**KIRKLEES METROPOLITAN COUNCIL
INVESTMENT & REGENERATION SERVICE**

Reference No: 2018/62/91621/W

Site Address: 35, Holly Road, Thornton Lodge, Huddersfield, HD1 3SE

Description: Erection single and two storey rear extension, front and rear dormers and front porch

Drawing Title.
Existing / Proposed Site Plan

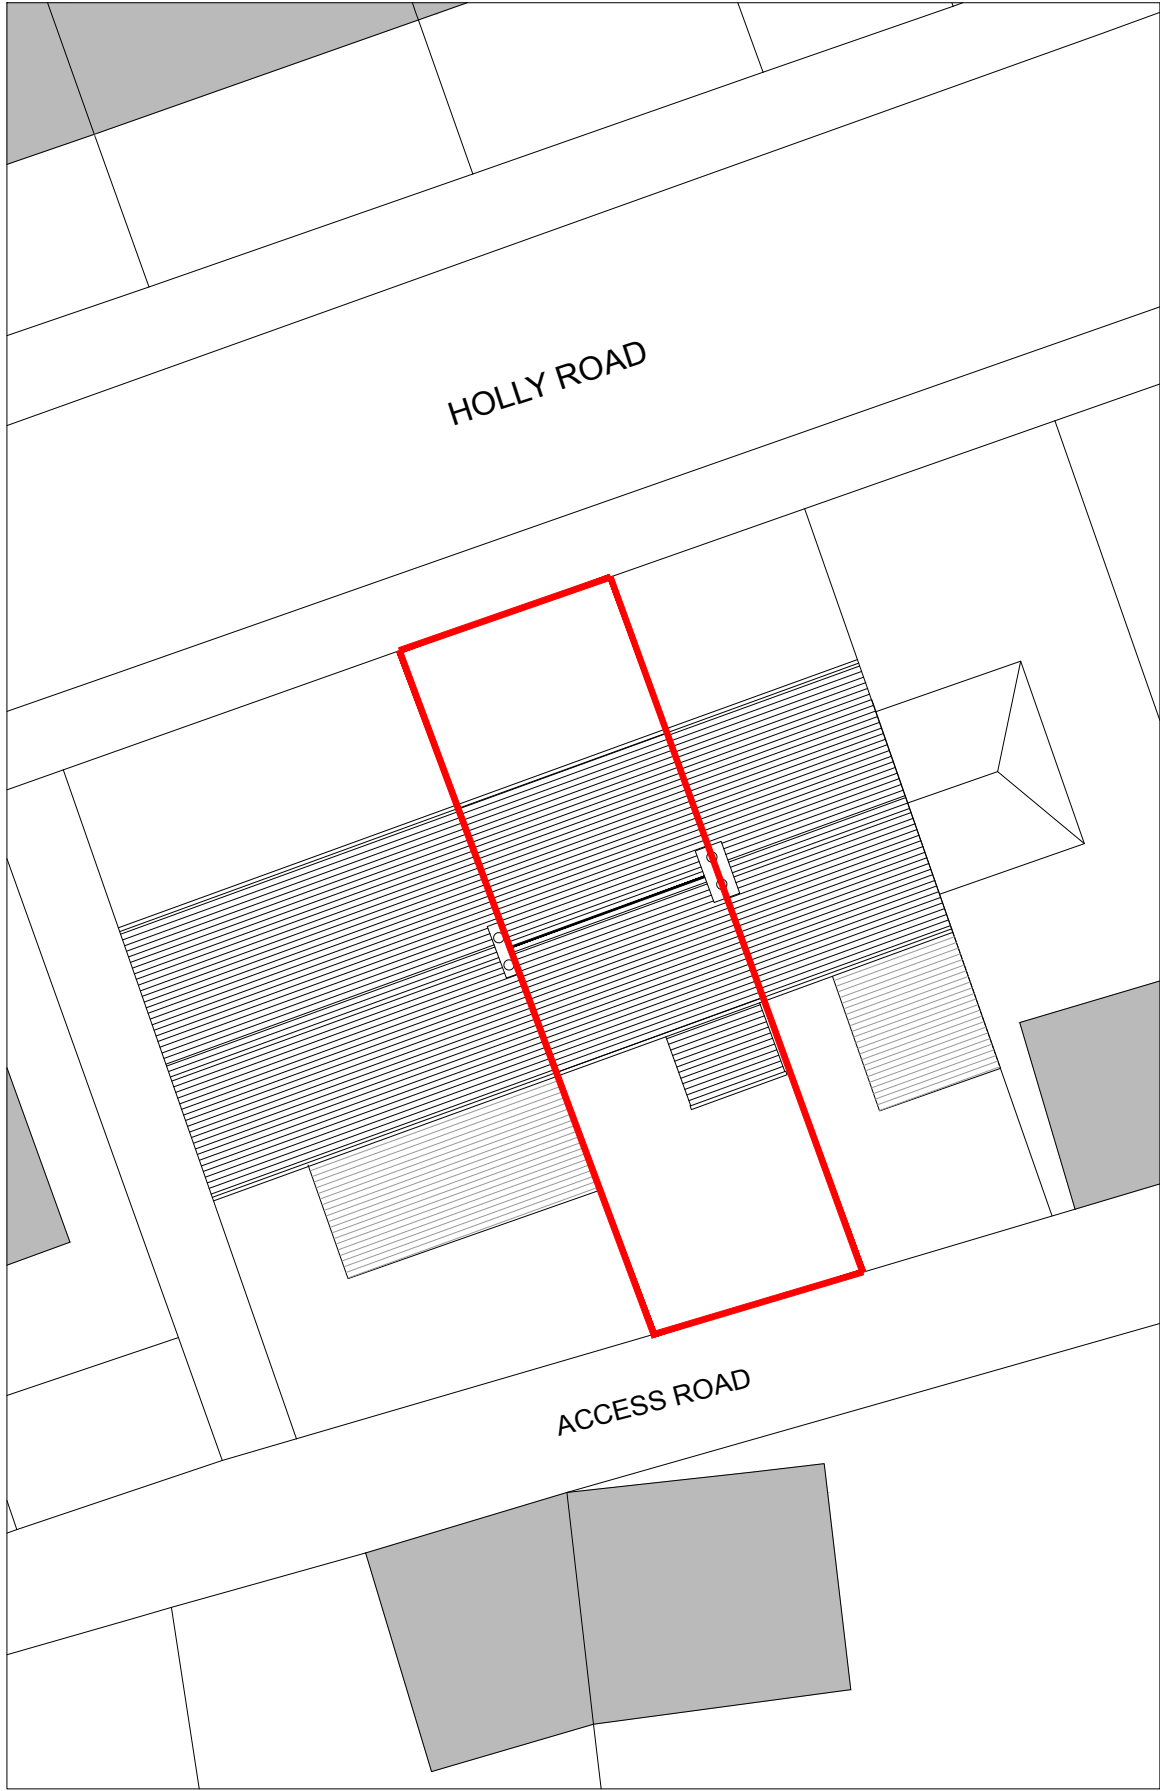
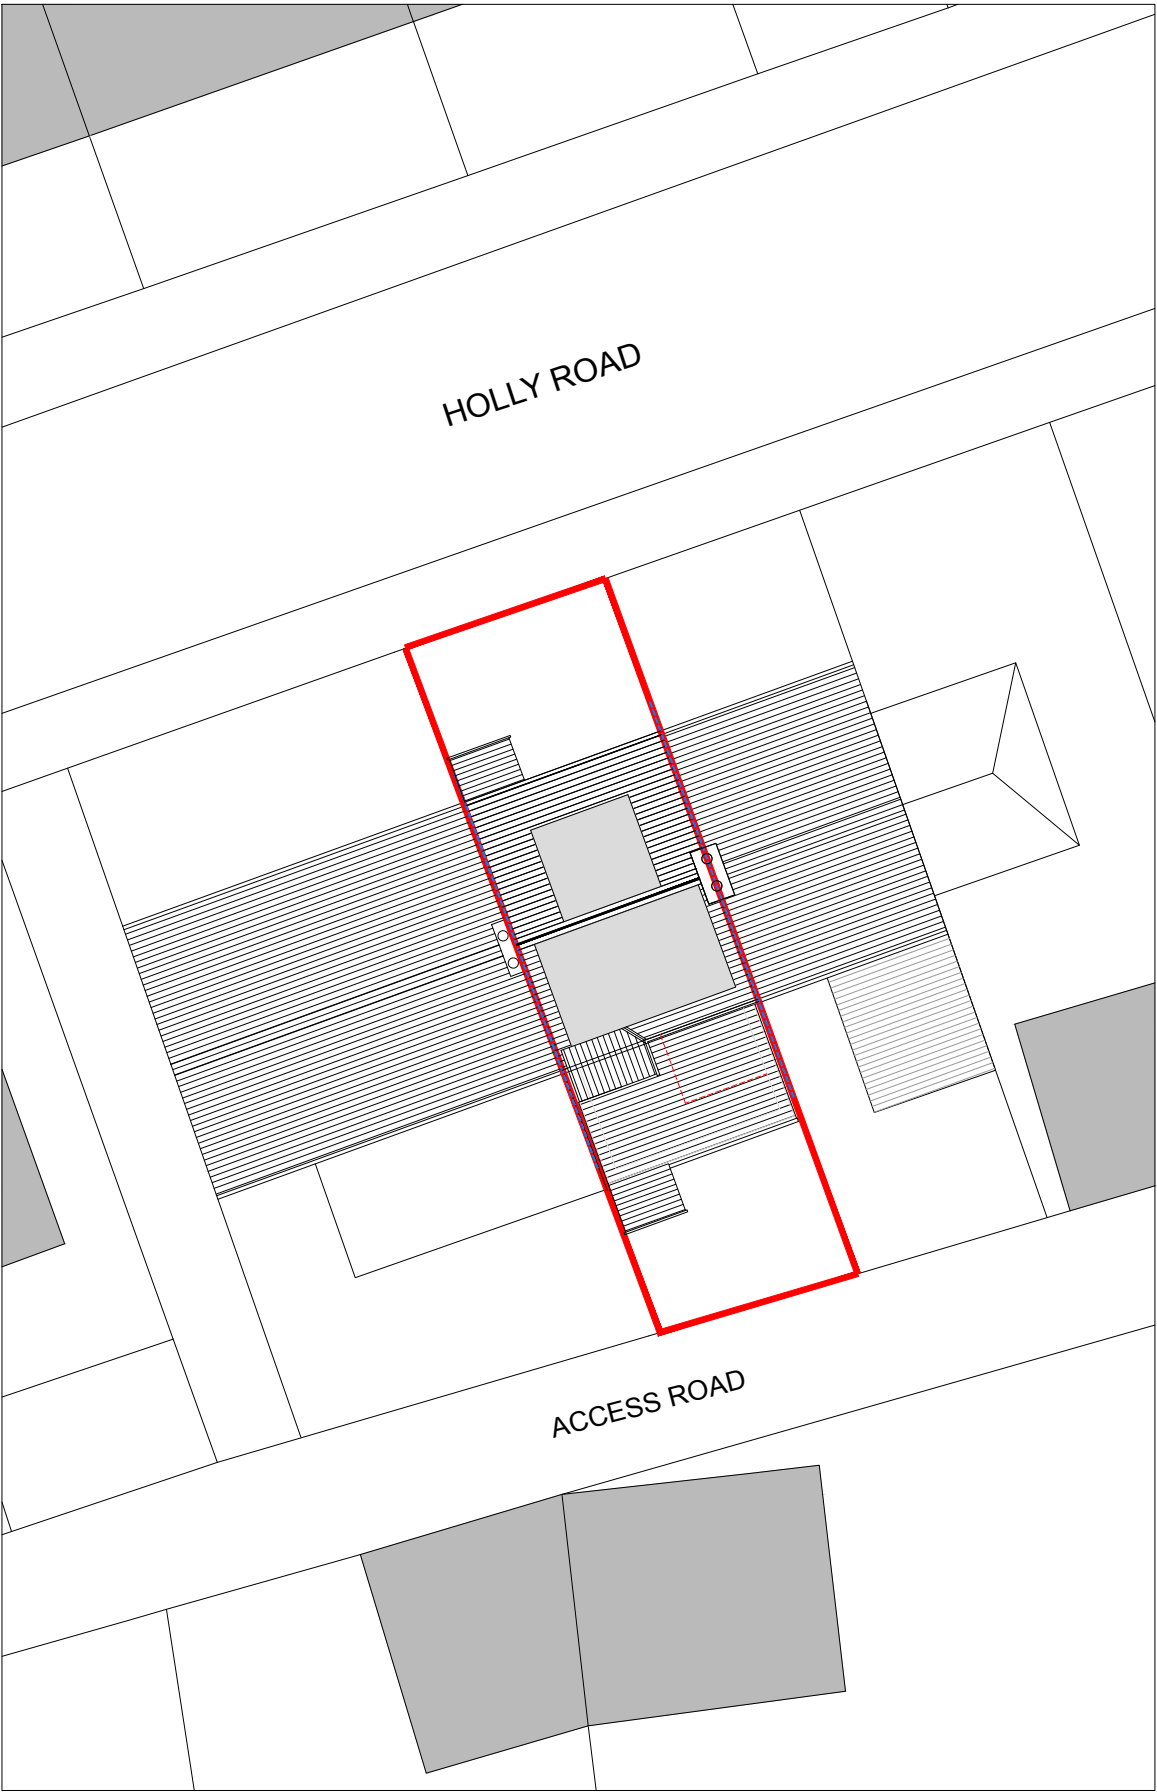
K.C. Highways Development Management – prior to the submission of amended plans a swept path analysis for the access and egress of a large car from both proposed parking spaces was required. Following the submission of amended plans and the parking spaces omitted, given that the proposal is not dramatically greater than the dimensions of an extension allowed through permitted development, no objection.

Prior to the submission of amended plans, parking spaces were proposed to the front and rear of the property. Highways Development Management raised concerns regarding the spaces and the dimensions not being of sufficient size to manoeuvre into either space without encroaching onto third party land, if at all possible. Therefore, a swept path analysis was required to be submitted. Included within the amended plans is the omission of the parking spaces. The accompanying email to the amendments cites that the applicant has requested that the introduction of the new driveway access from Holly Road be omitted from the proposal and the rear yard can accommodate 1 no vehicle as per the existing on-site parking provision. Highways Development Management were re-consulted on the proposed amendments and whilst the dwelling would still have under the recommended level of parking provision, given that the proposal is not dramatically greater than the dimensions of an extension allowed under permitted development, they do not wish to object to the proposed scheme. As such, there are no concerns and no conditions deemed necessary for the development.
